Subject: **Application for Modification to Section 404 permit and Section 401 Water Quality Certification** for the Owen Drive Extension from I-95 Business to NC 87 located southeast of Fayetteville, North Carolina in Cumberland County. Federal Aid No. STP-0620(1); State Project No. 8.2441101 TIP No. U-2912; \$475.00 Debit work order 8.2441101, WBS Element 34885.1.1. NCDOT Division 6. NCDENR-DWQ Water Quality Certification Project No. 041244 and USACE Action ID 200000913.

The purpose of this submittal is to request a modification to the Section 404 Individual Permit and Section 401 Water Quality Certificate. The modification for the permit is for changes to the wetland delineation and stormwater design change at Site 3.

#### Permit Drawing 5 of 10/Site 11/ Plan Sheets 11 and 12

CLEARING AND GRUBBING
EROSION CONTROL FOR
CONSTRUCTION SHEET 11

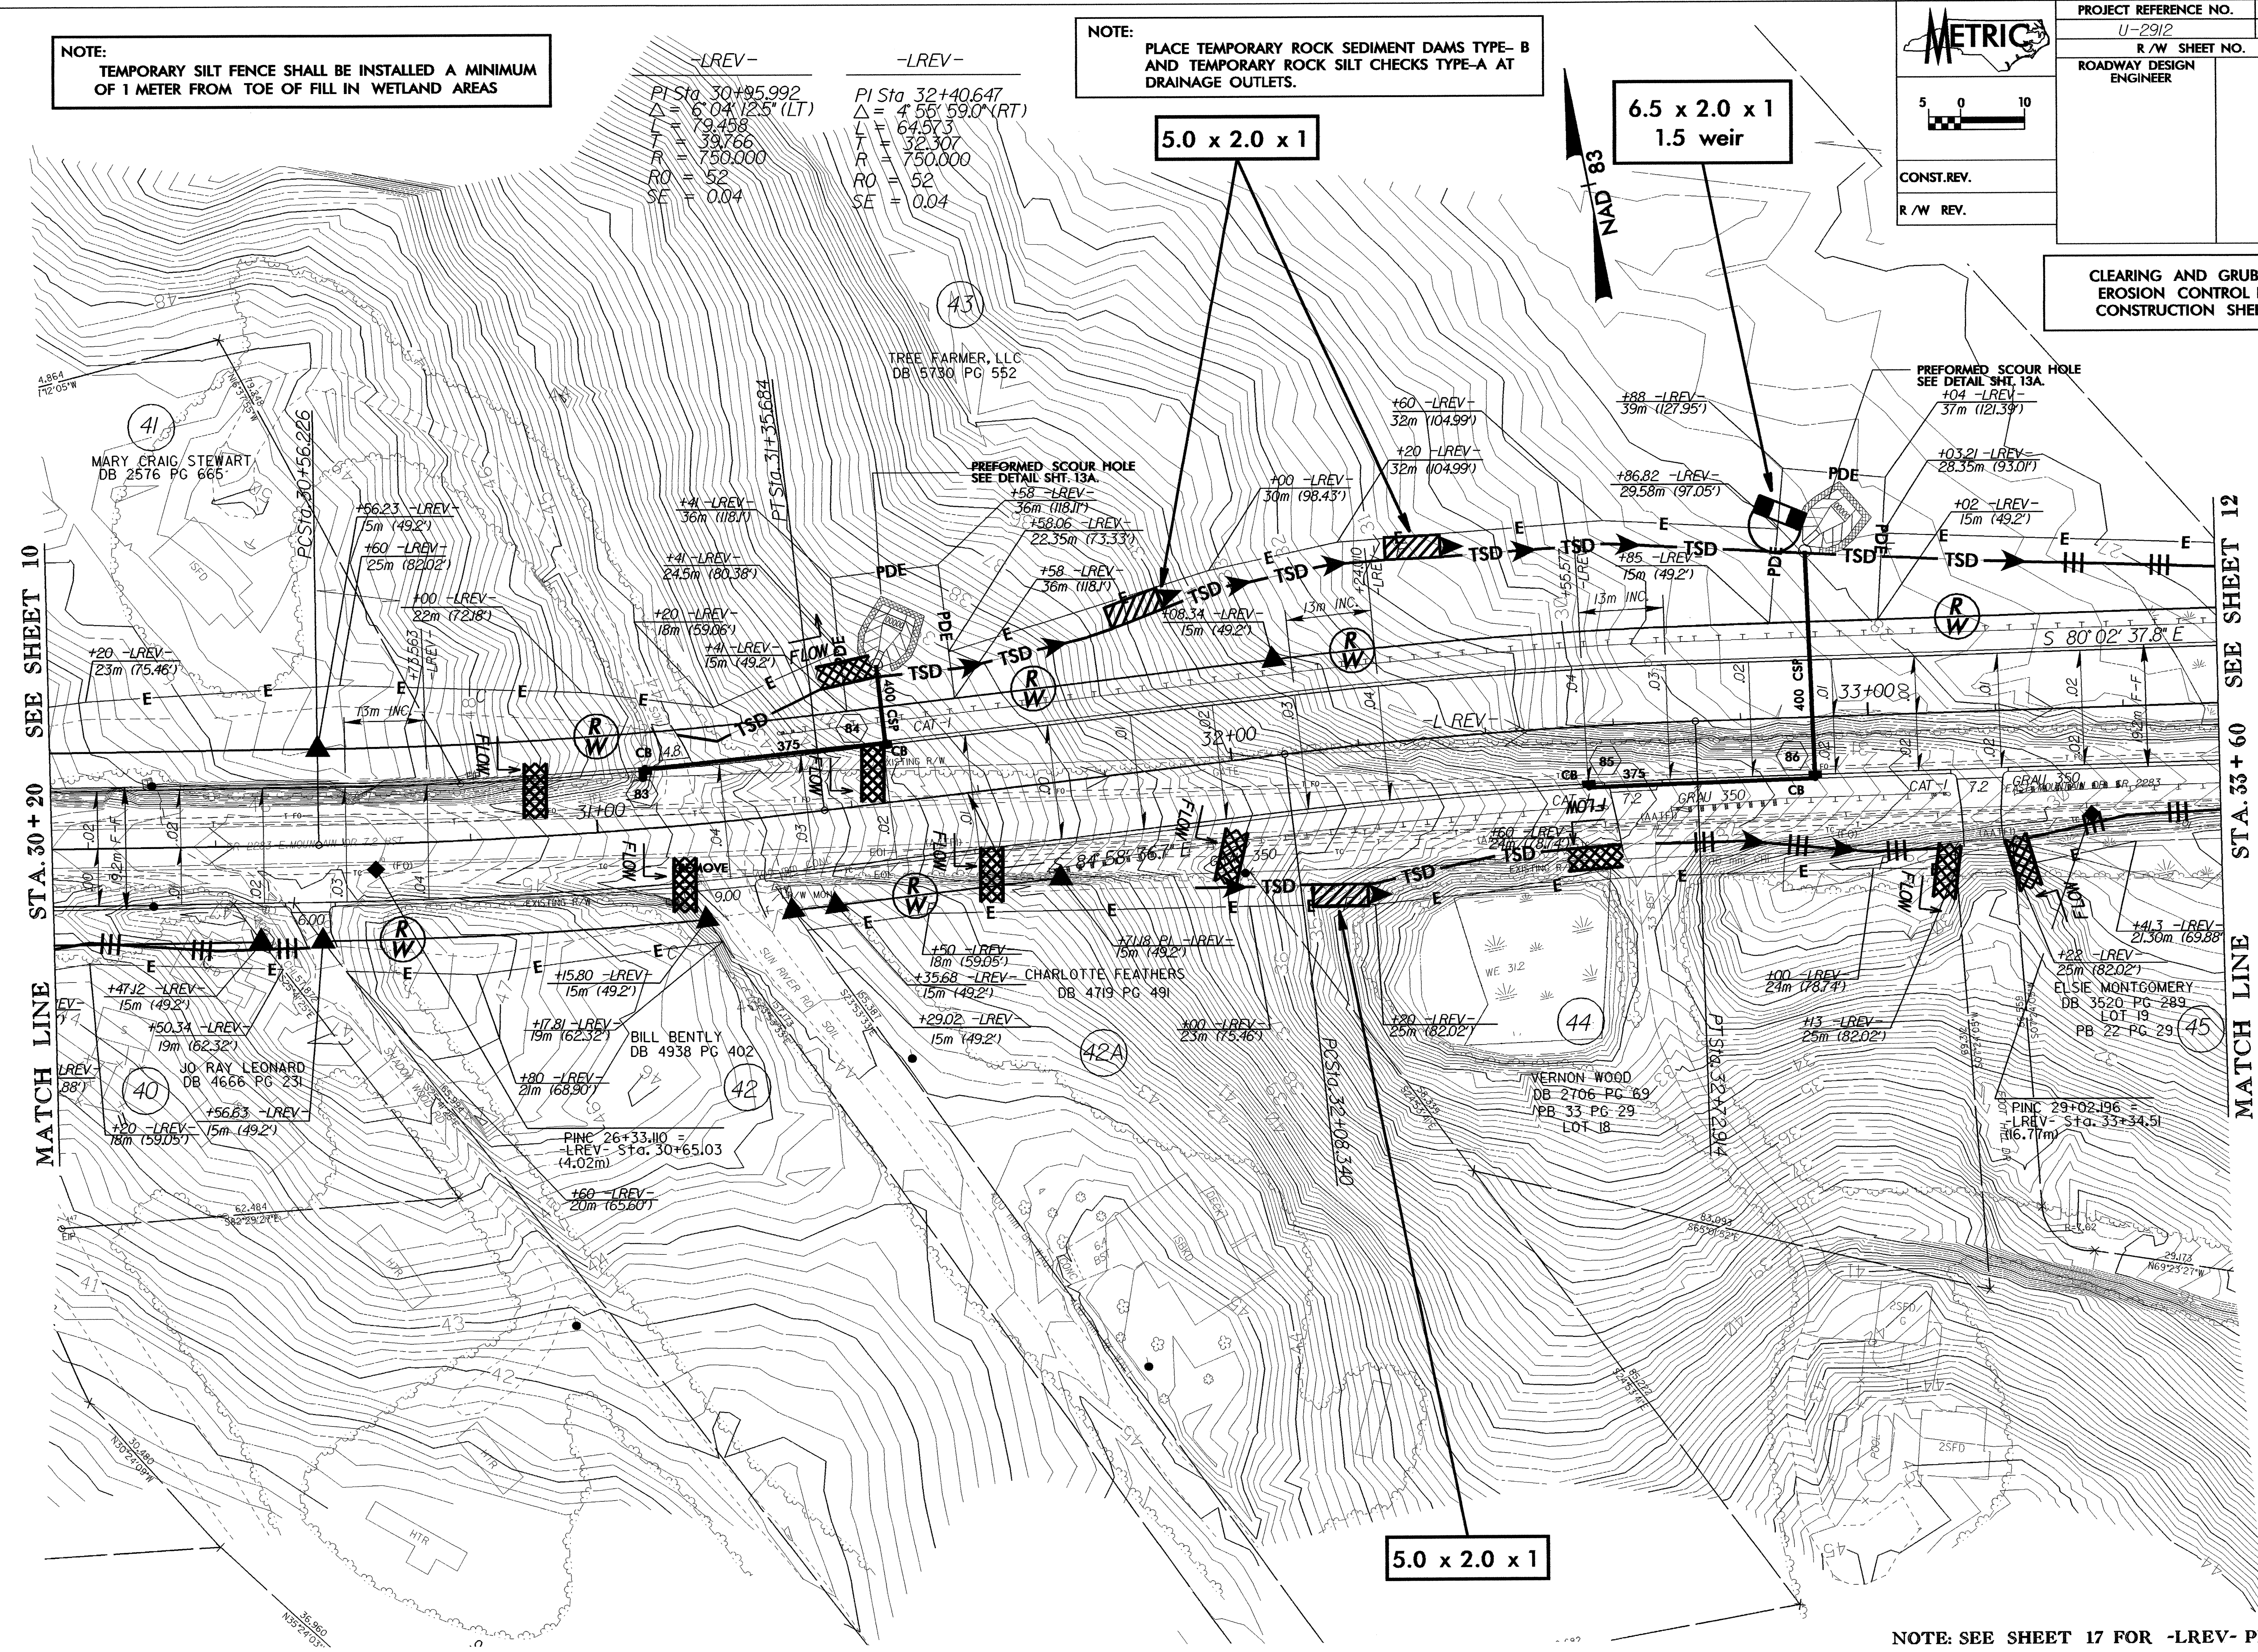
The original permit drawing contained an error in the wetland delineation at this site. The wetland line was extended to the north on November 22, 2004 by EcoScience biologists. The original stormwater design had a lateral V ditch in what is now part of the wetland system. The permit drawing and plan sheets were changed to show the stormwater now diverted to the lateral base ditch near Station 34+00. Additional riverine wetland impacts at this site for mechanized clearing is 0.07 acre. The amount of fill in wetlands at this site was reduced by 0.01 acre. This is a net of 0.06 acre of additional wetland impact.
